Name of Project: Carolina Diesel Trucks

September 29, 2017

Re: Carolina Diesel Trucks
6296 Progress Drive
Fuquay Varina, NC 27526

Application Number 17-50041710

A-03

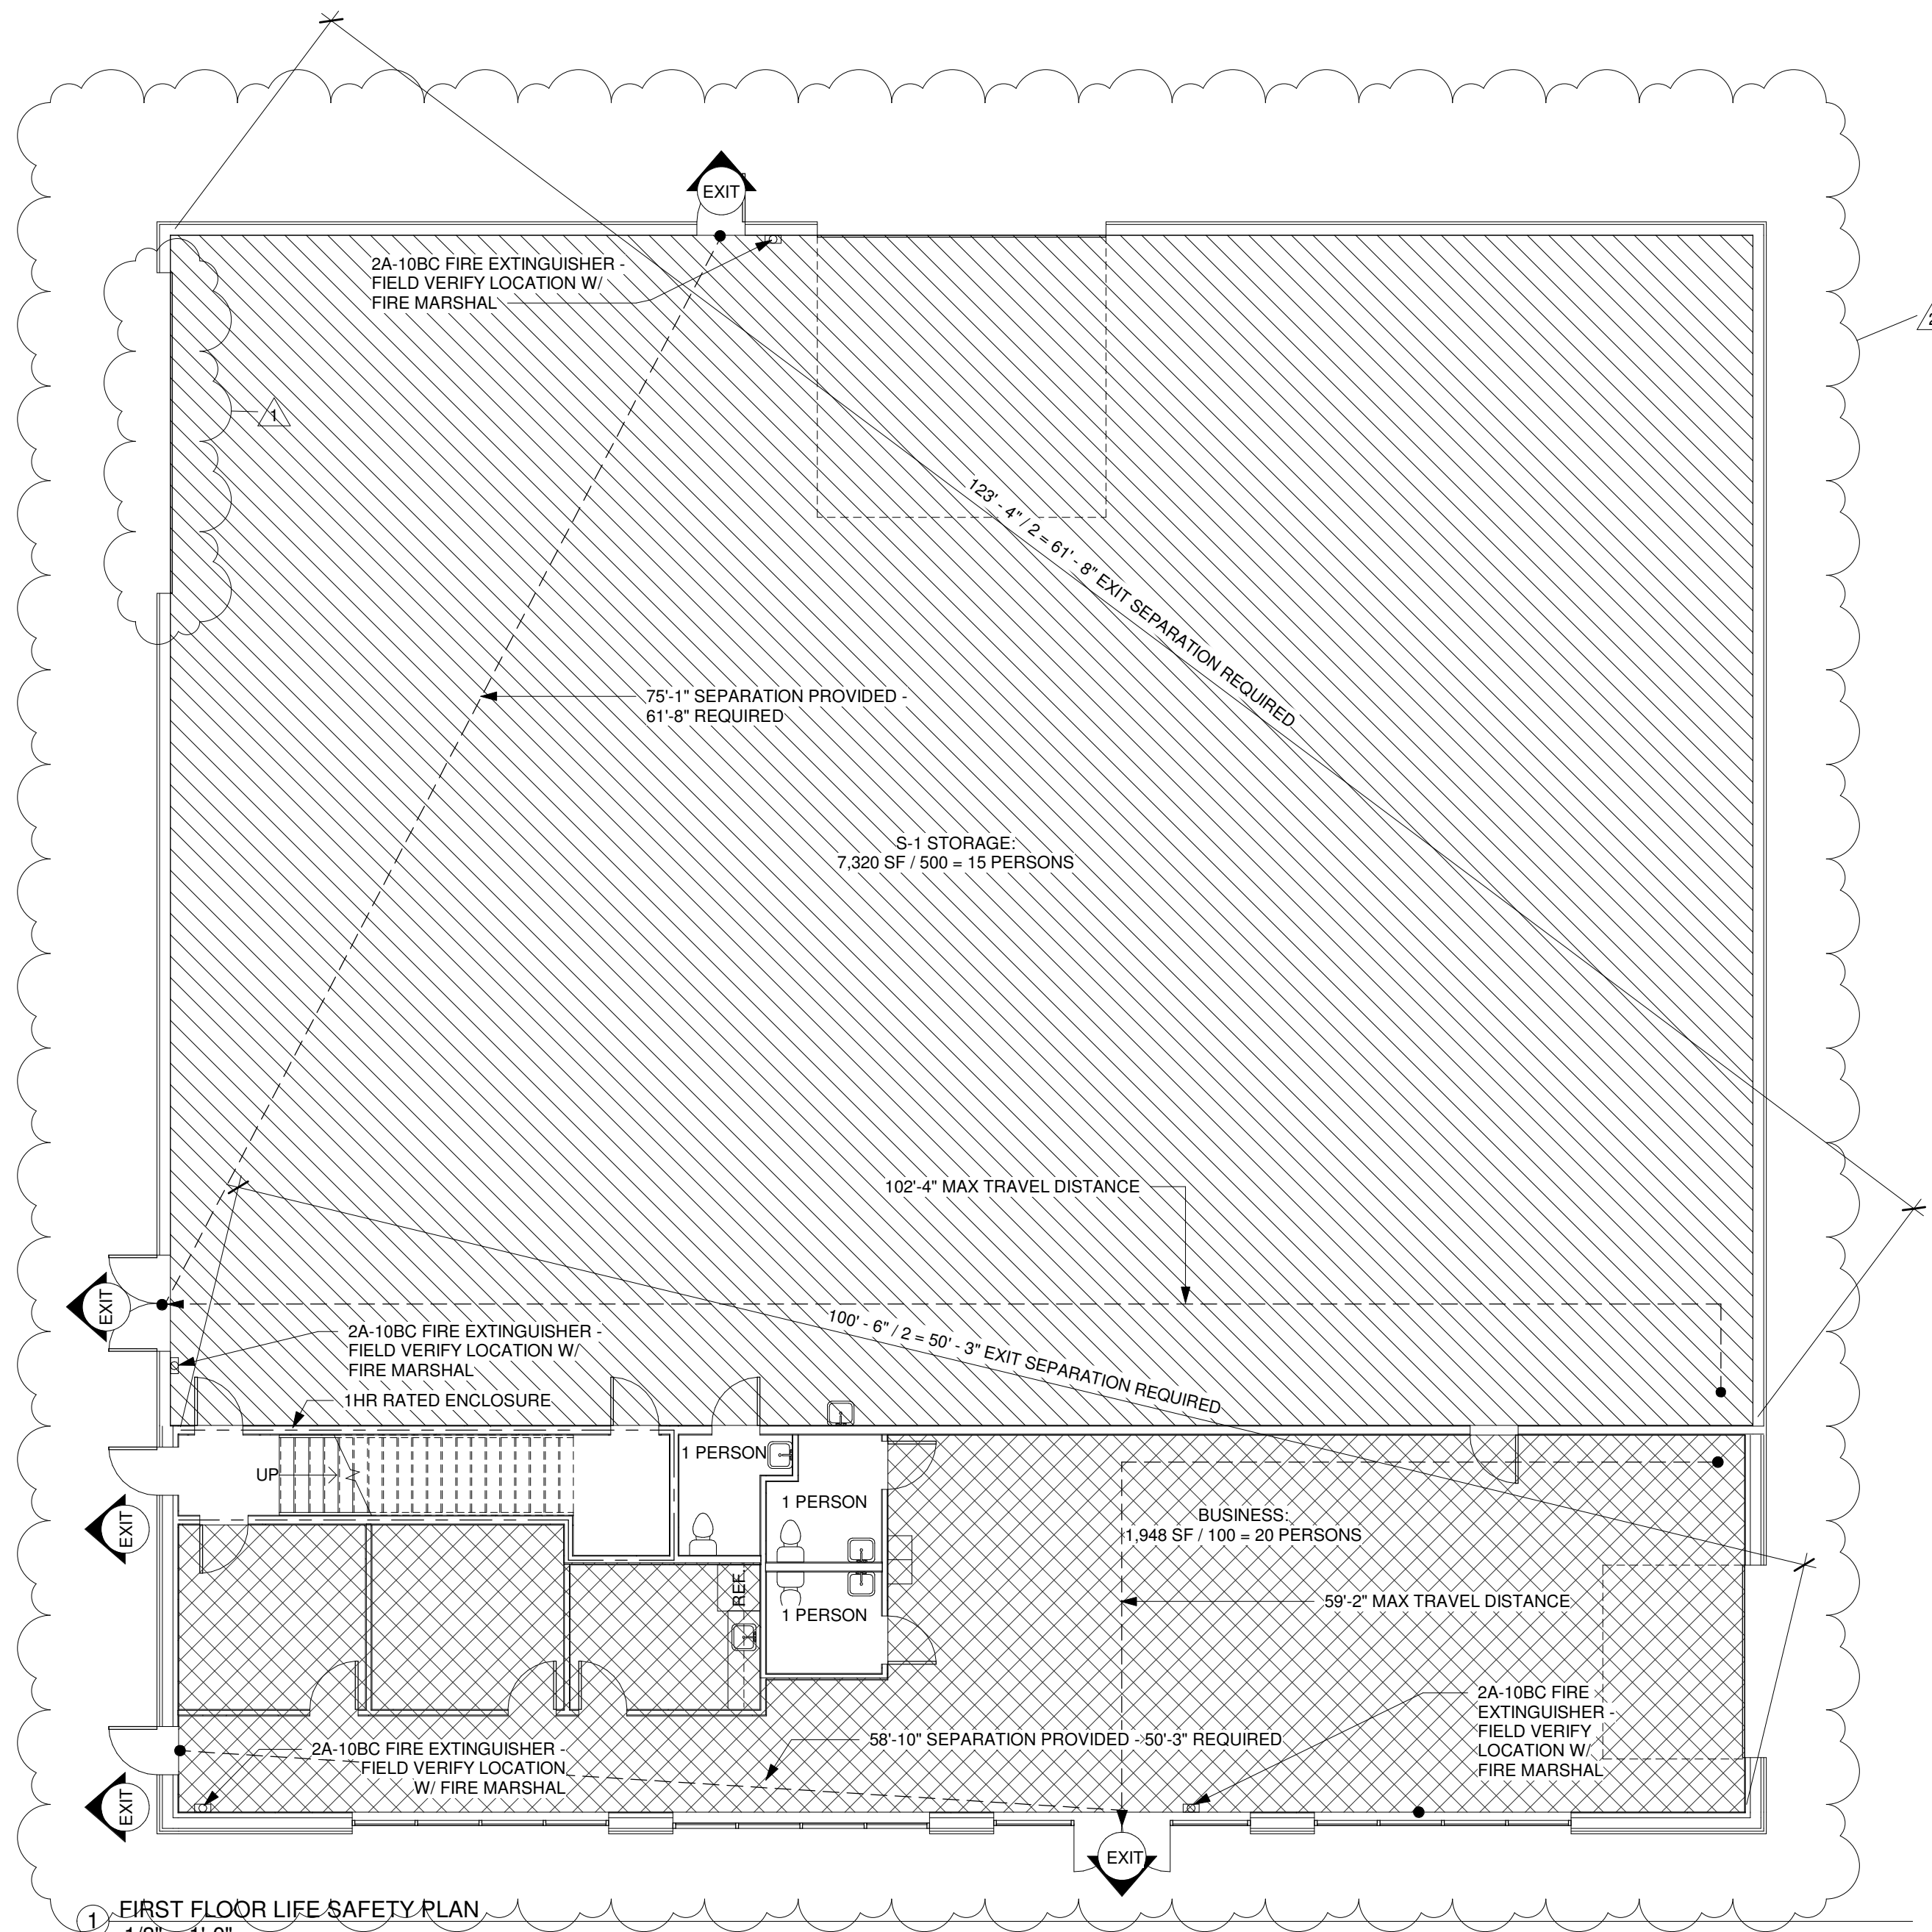
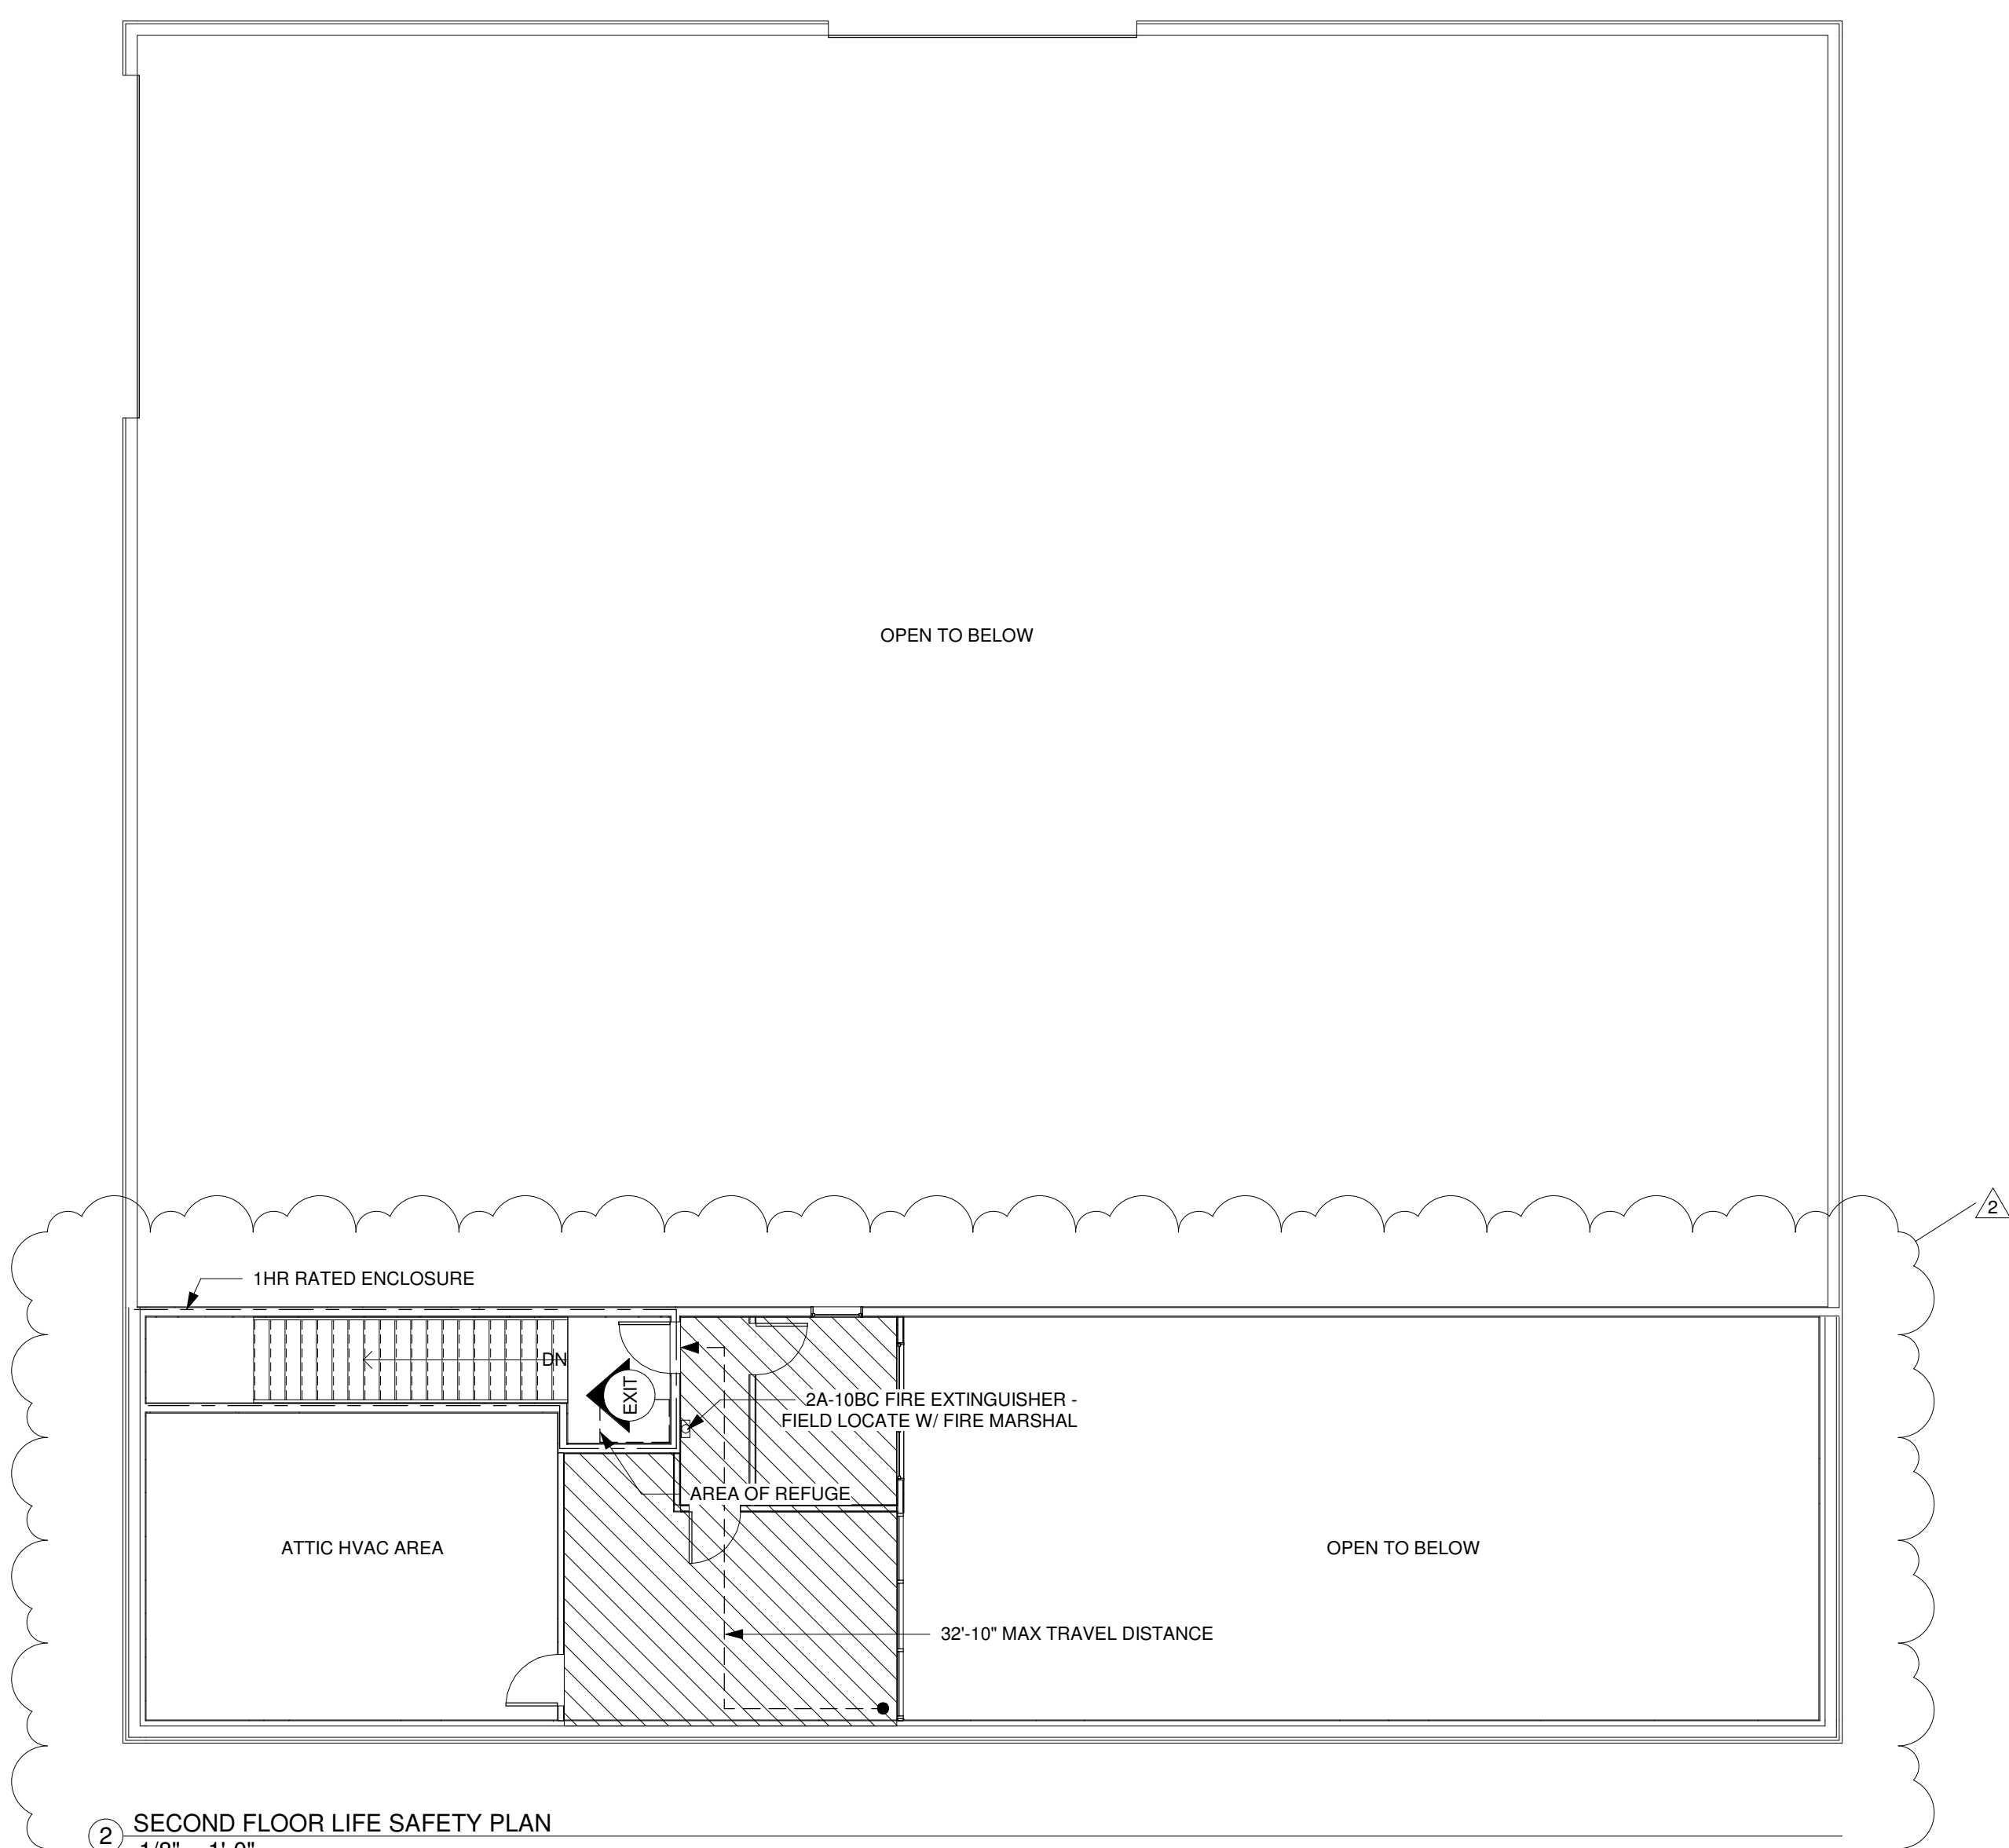
- **Fire Extinguishers**
 - Fire Extinguishers shall be 2A:20BC and shall be placed with a travel distance to not exceed 75'

- Fire extinguishers are to be mounted no higher than 5' above the finished floor.

- **1006.1 Illumination Required**
 - The exit discharge shall be illuminated at all times the building spaces served by the means of egress is occupied
 - Illumination level in all areas of the means of egress shall not be less than 1 foot-candle at the walking surface and shall have emergency power supply.
